## West Midlands Interchange

### Critical Examination of the West Midlands Interchange Application Documents relating to Highway and Transportation

Technical Note: Prepared on behalf of Stop the WMI

Project Ref: 19-053, January 2019

TITLE:  
Pedestrian Accessibility

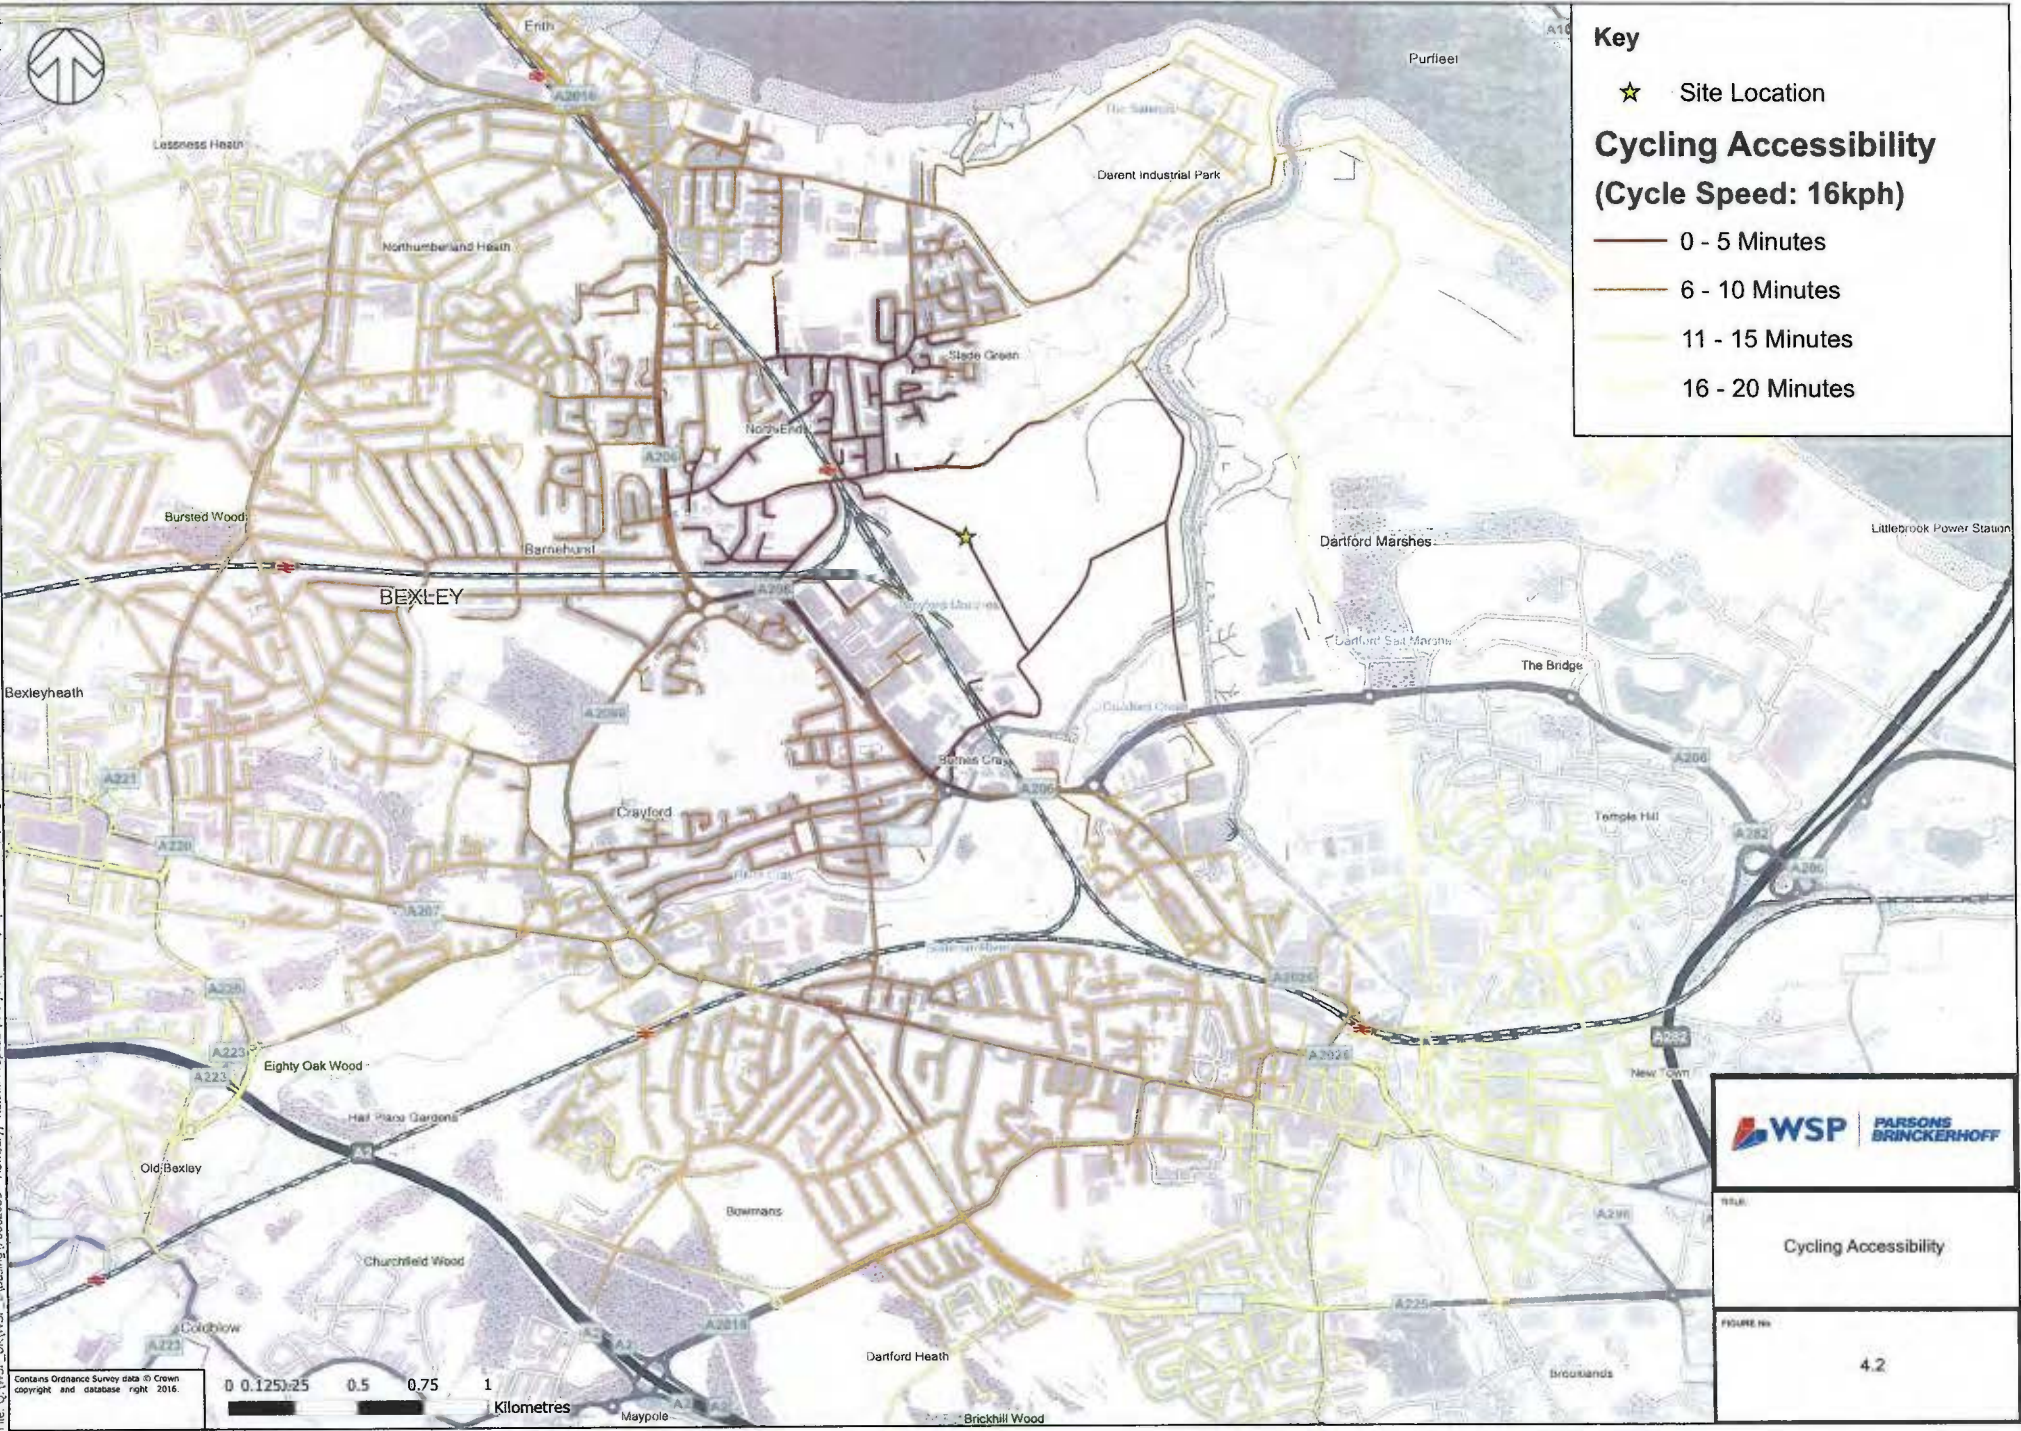
It is also noted that the pedestrian catchment in Figure 7 does not provide access to any amenities or surrounding residential conurbations and as such, there is also a very low chance of 43 employees walking (86 reported estimated daily walking trips).

TITLE:  
Indicative Route of Shuttle Bus Service

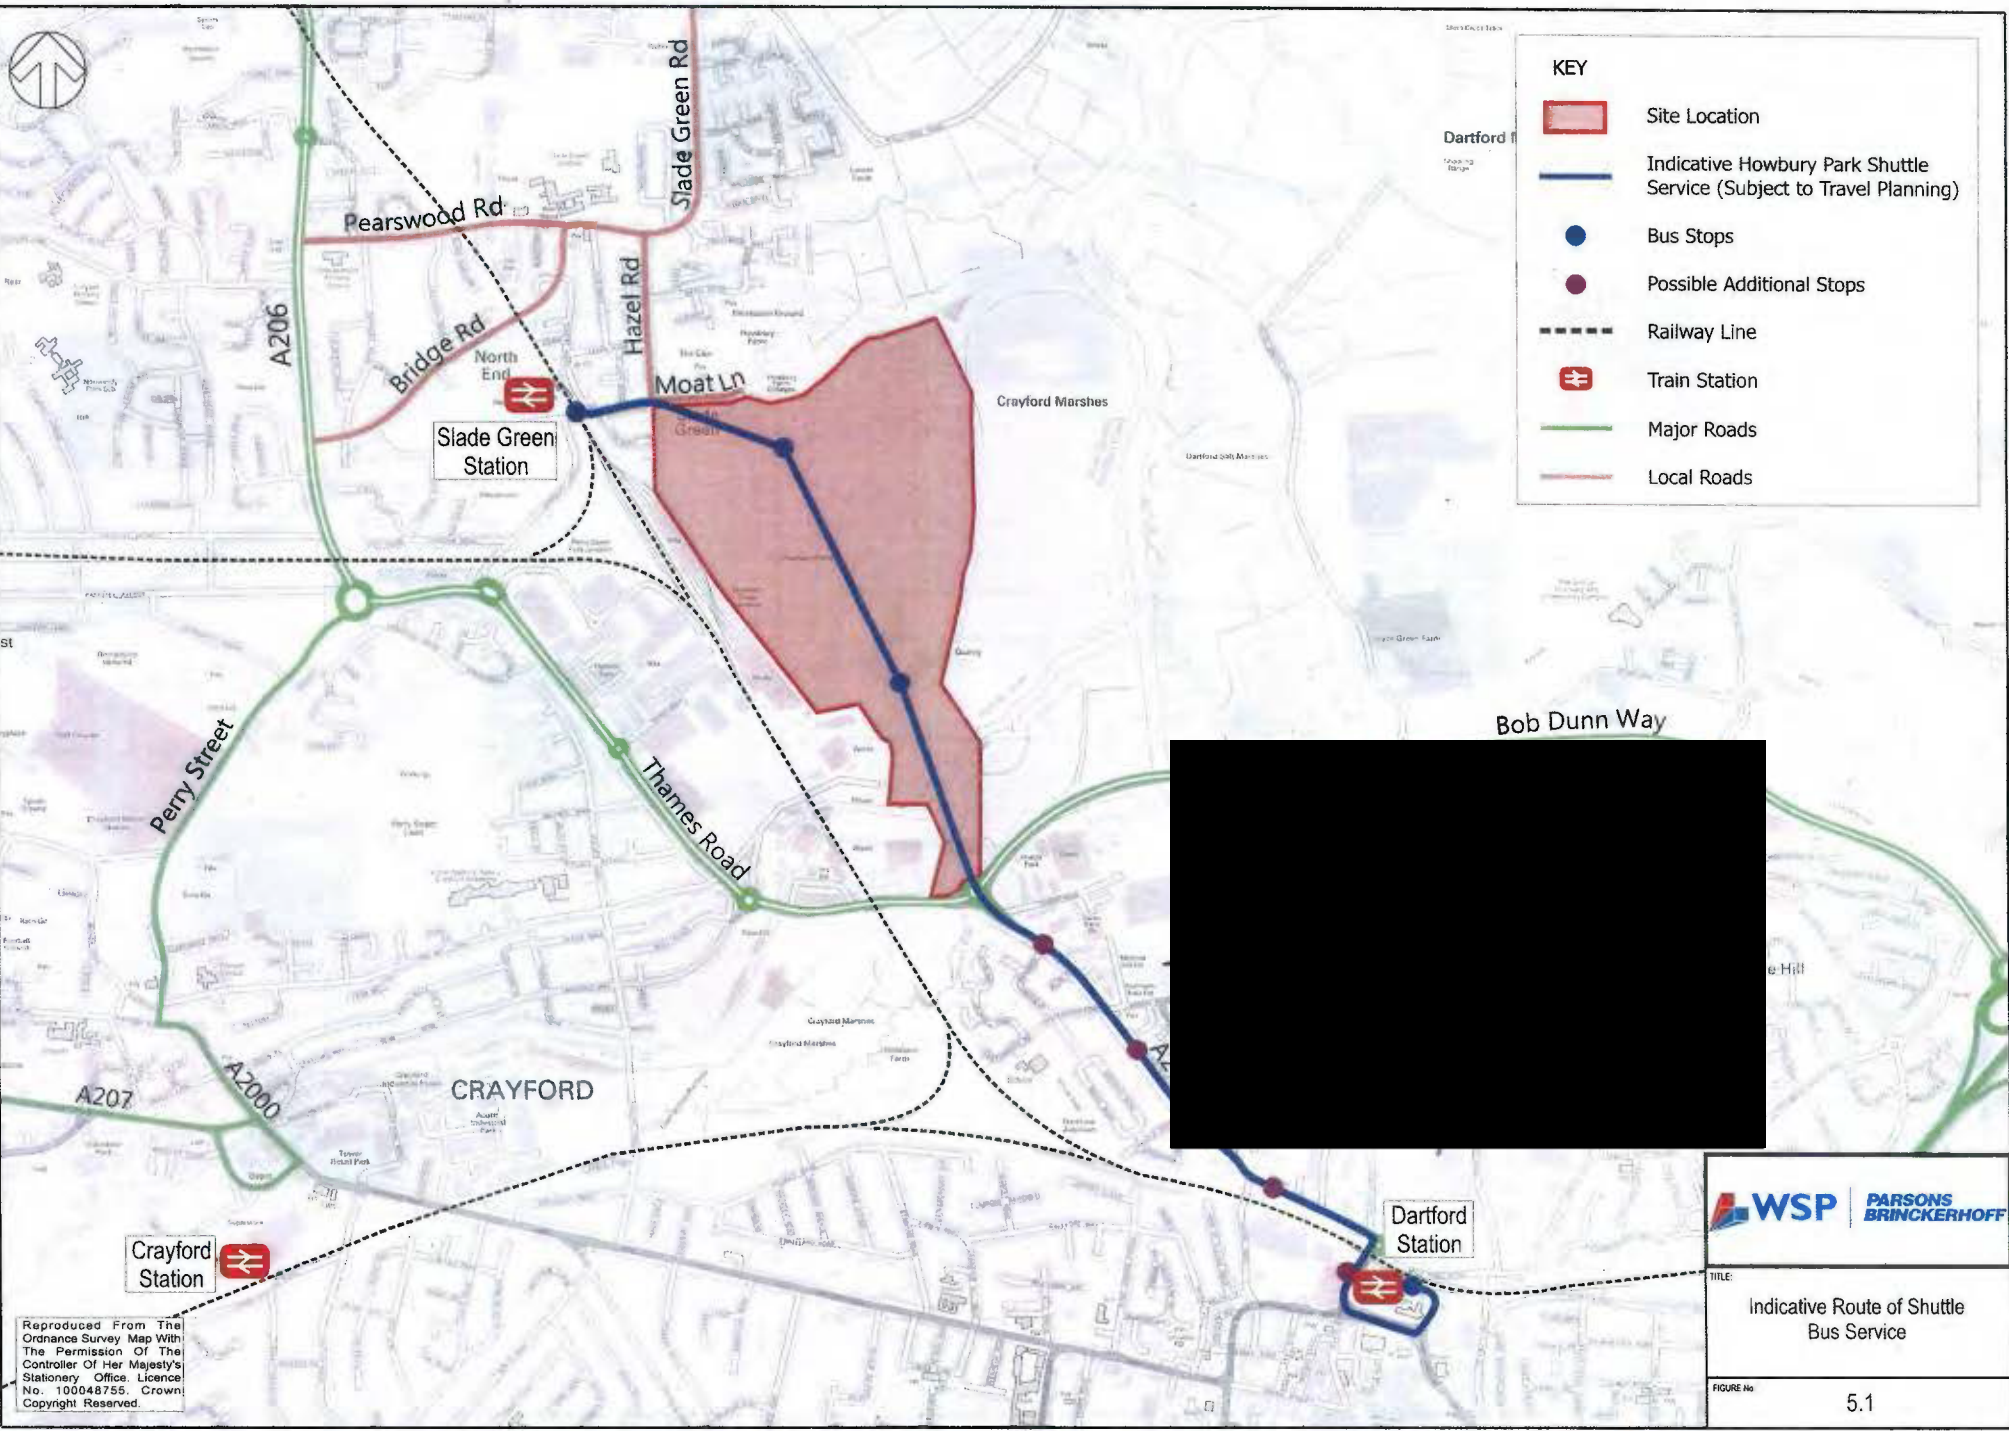
Providing the shuttle bus will serve the areas of highest forecast employee numbers and trip demand as approximately 32% of future workers are estimated to reside in these areas. This indefinite comment about the implementation of a shuttle bus service has no accompanying description, frequency or operator and is not considered to be enough to comprehensively mitigate the reliance on private car to access the site.

Notwithstanding this, the calculation also assumes that 68% of future workers will originate from other areas and thus, cannot benefit from the proposed shuttle bus service. It is not outlined within the Travel Plan how public transport would service the remaining 68% of 8,550 employees to deter travel by private car and enable the WMI to achieve the 8% quoted Travel Plan target.
